From: Janice Chapman
Sent: 18 February 2014 15:50
To: [REDACTED]
Subject: BE/4/14 - Loft conversion with front and rear dormer at 40 Norbren Avenue, Bersted

Proposed Front Elevation (North)

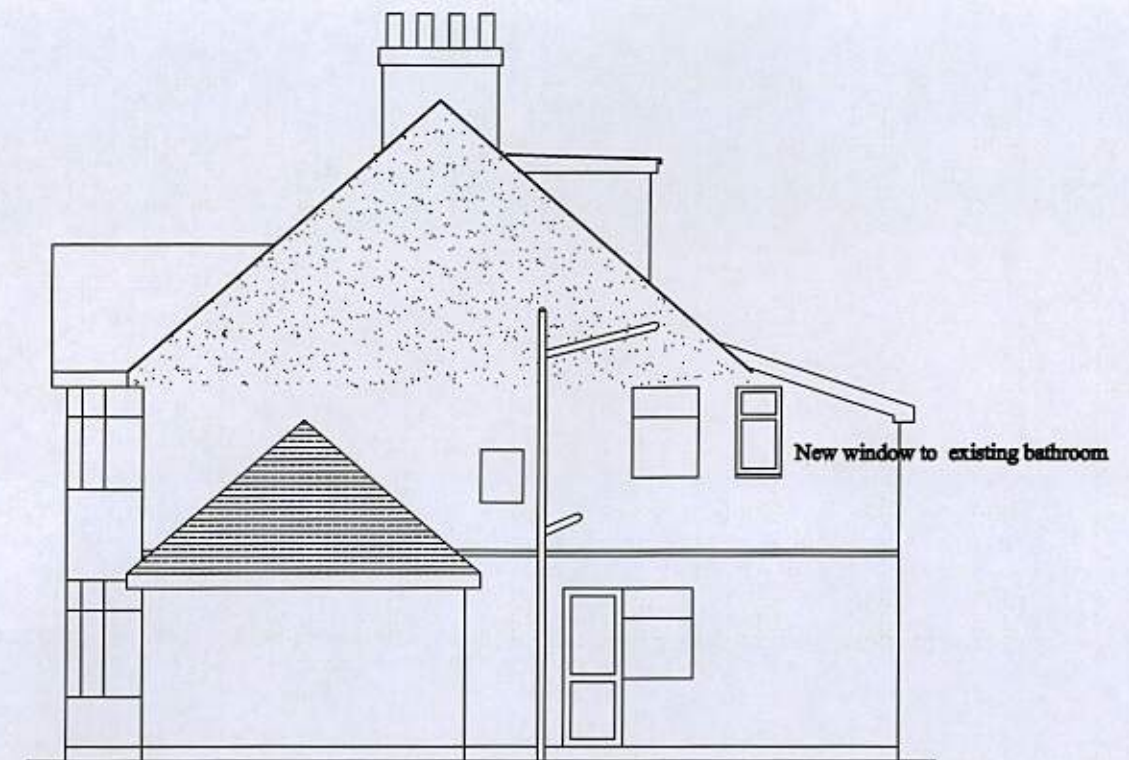
I have visited the site in relation to the above loft conversion. Whilst I have no objection in principle to the loft conversion with alteration to the roof the front dormer is not considered acceptable. There is the absence of front dormers in the surrounding street which are characterised by properties of similar style and design.

Would it be possible for the front dormer to be removed from the application.
